Recommendation Report for Planning Permission for Works or Extension to a Dwelling

REF NO: FP/125/25/HH

LOCATION: 14 First Avenue
Felpham
PO22 7LG

PROPOSAL: Single storey rear extension. First floor side extension above existing ground floor.

PROJECT
PROPOSED EXTENSIONS & ALTERATIONS
"PIPER'S GREEN"
1/4 FIRST AVENUE,
MIDDLETON-ON-SEA,
WEST SUSSEX PO22 7LG
DRAWING TITLE
PROPOSED ELEVATIONS

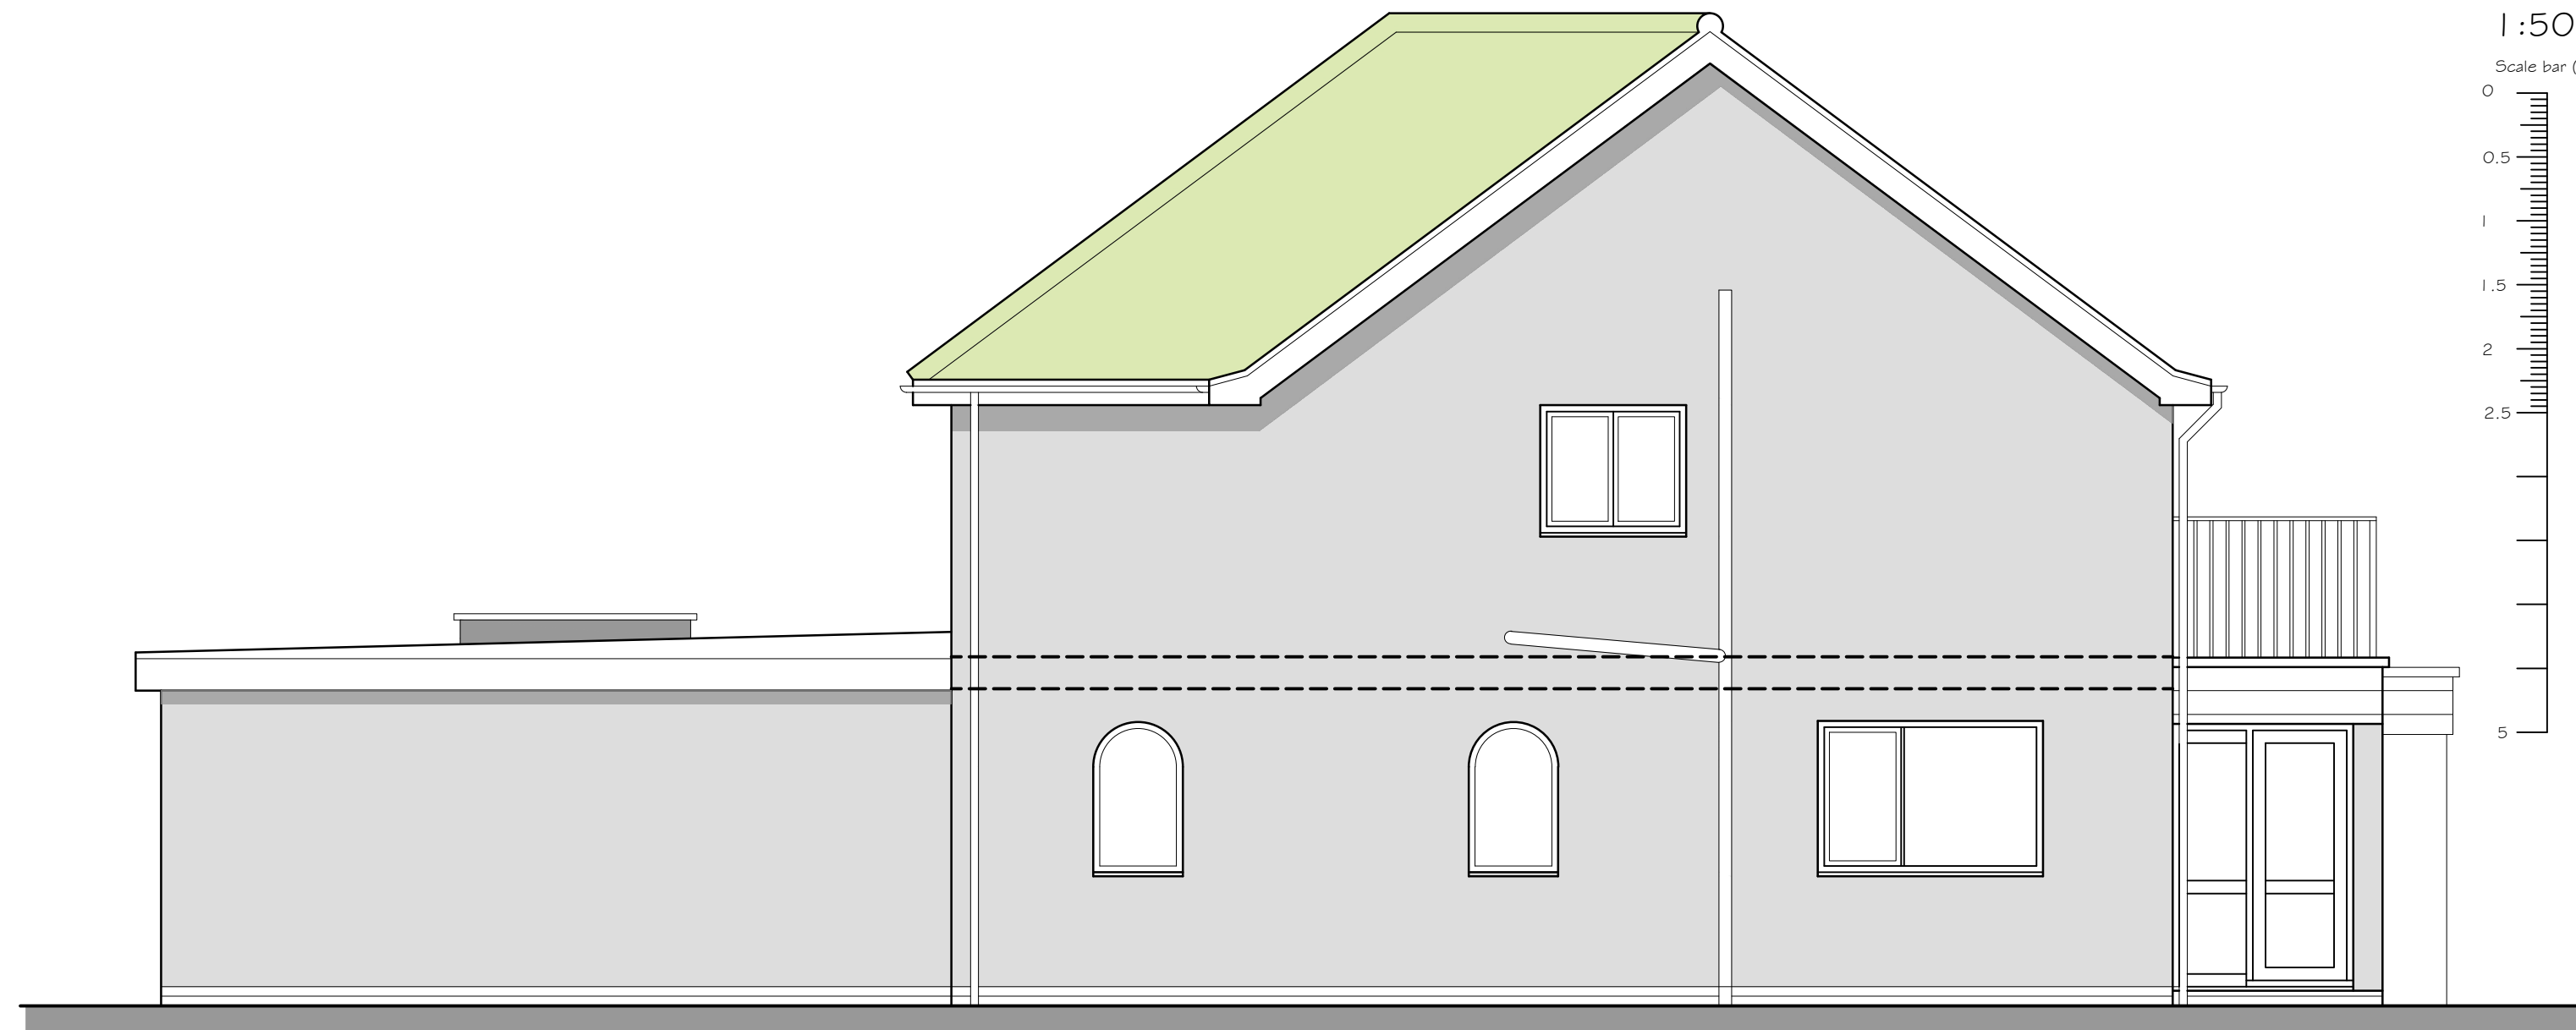
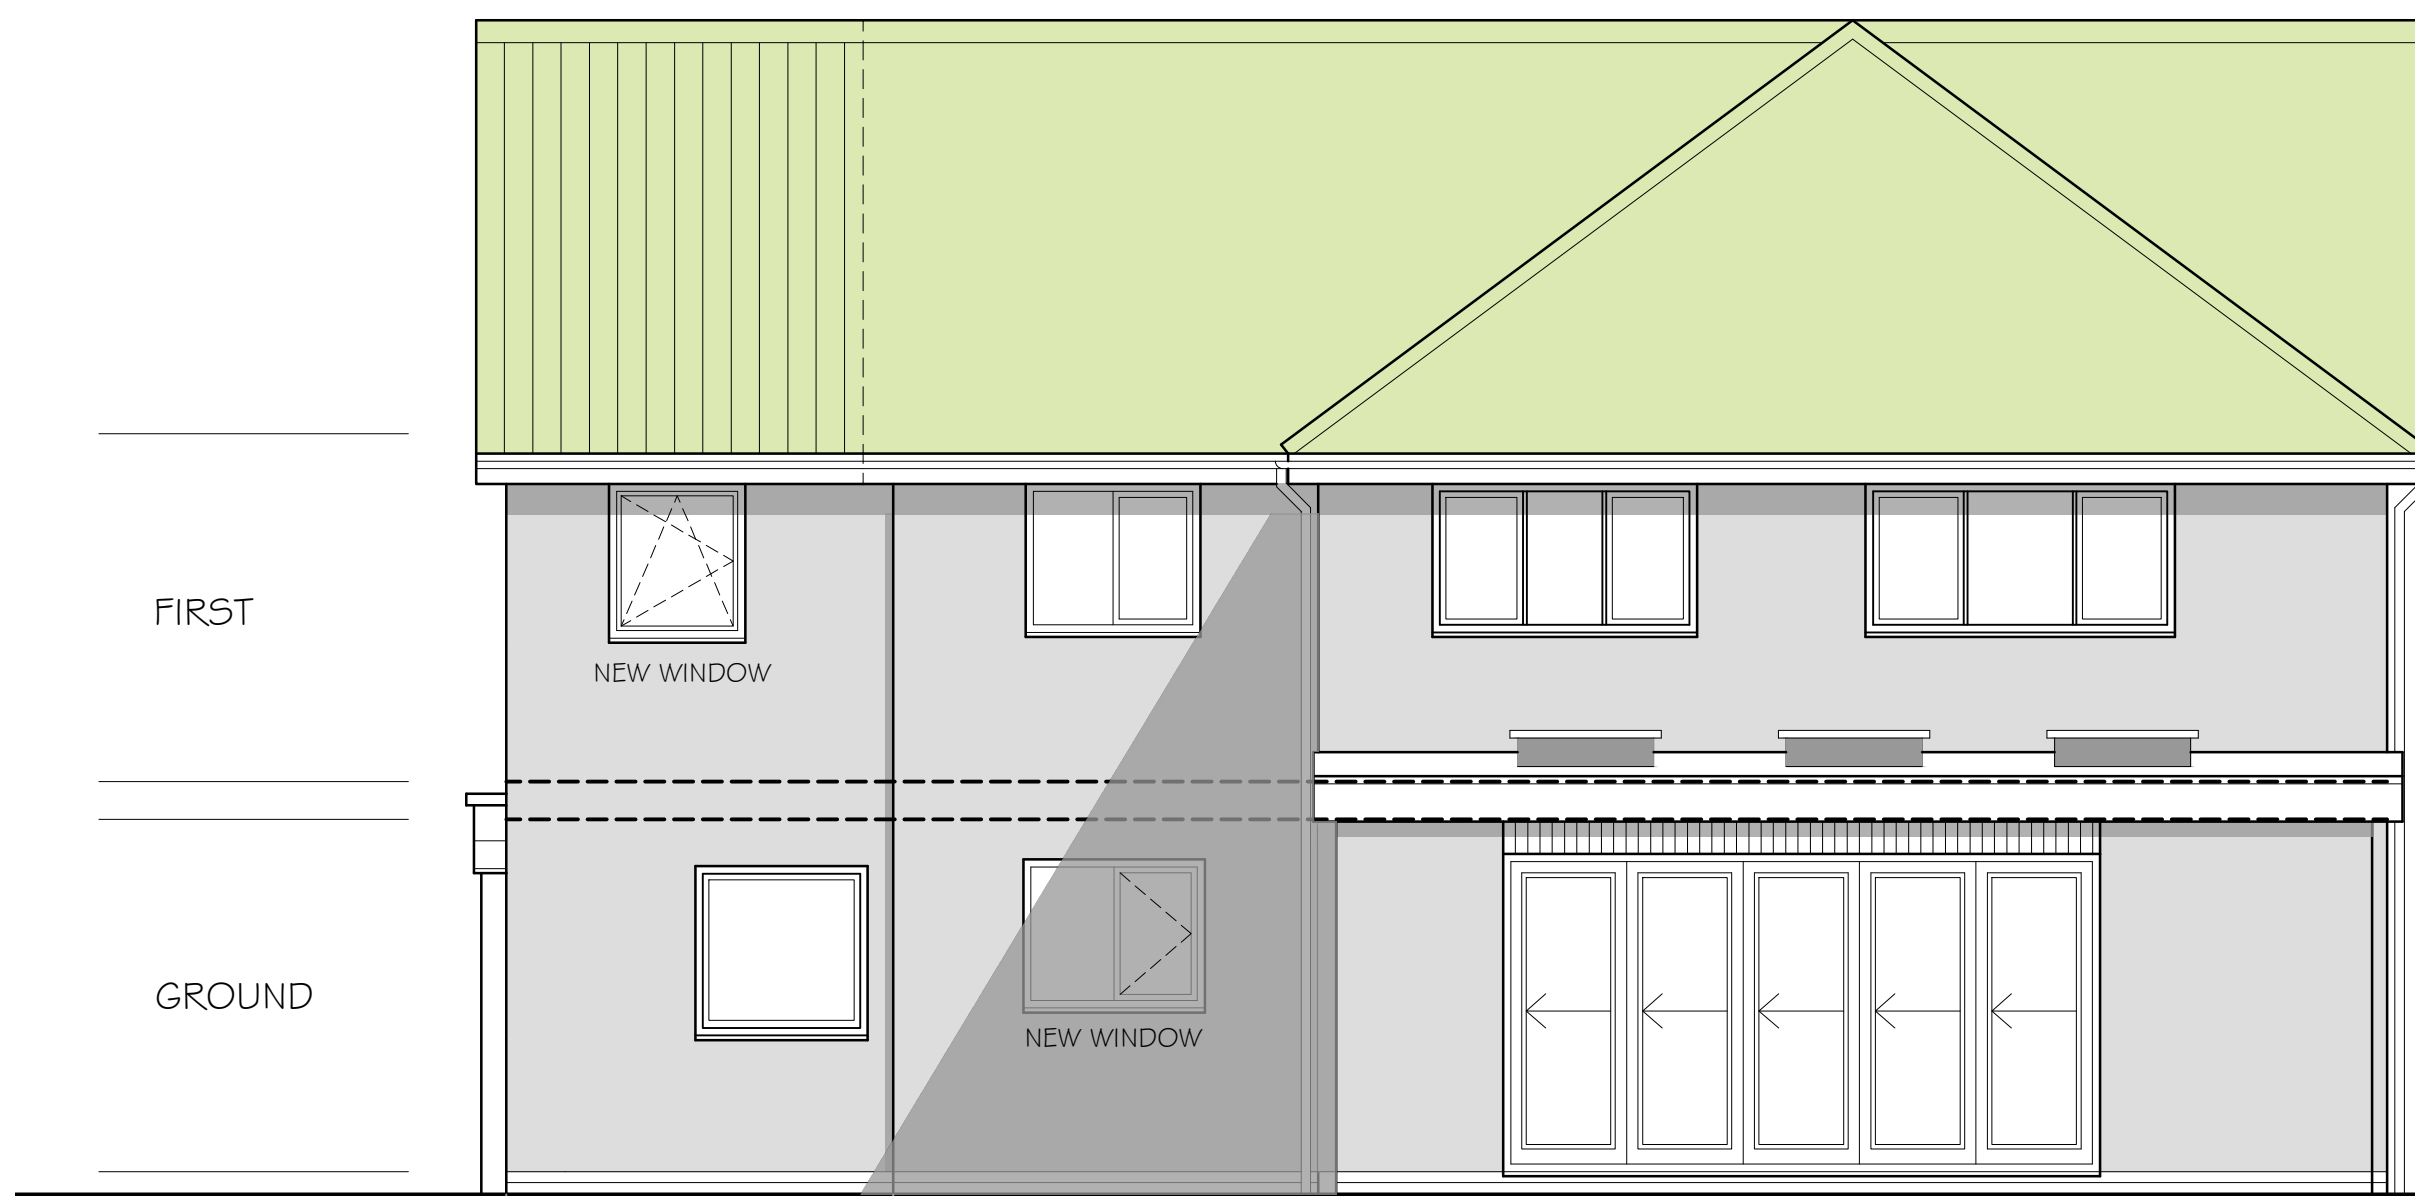
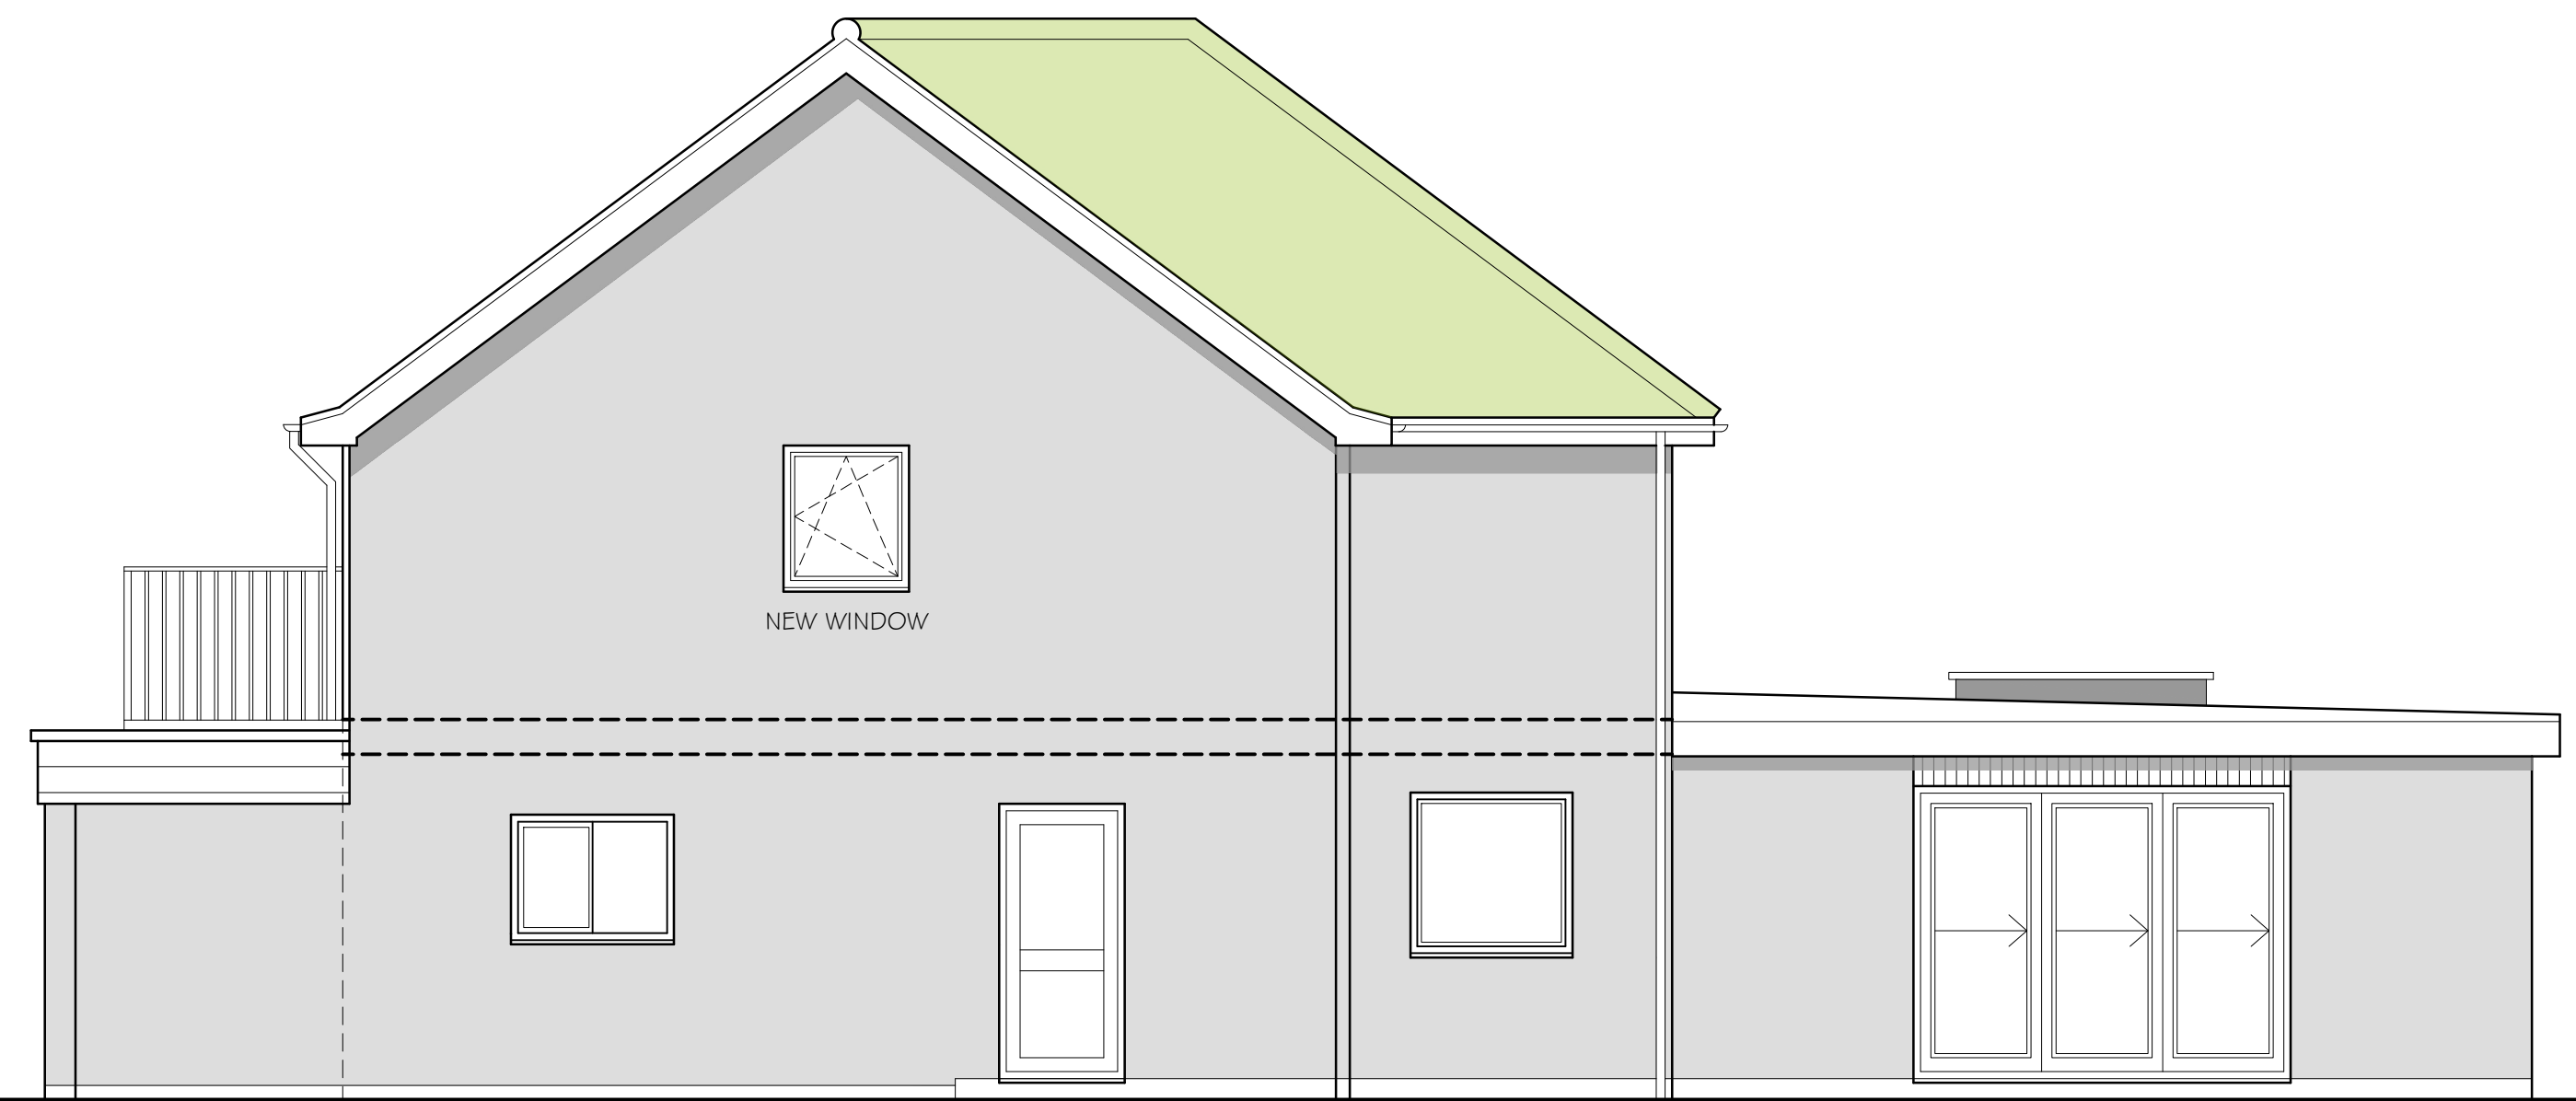
The first-floor side (north) fenestration would face the neighbouring property's dormer, which is fitted with

obscure glazing. Given the proximity to the boundary, it is appropriate to impose a condition requiring the proposed first-floor side (north) fenestration be obscure-glazed and non-openable below 1.7m above the internal floor level.

- 3 The fenestrations of the rear (west) and side (north) first-floor extension elevations hereby permitted shall be obscure-glazing, and non-opening unless the parts of the window which can be opened are more than 1.7 metres above the floor of the room in which the window is
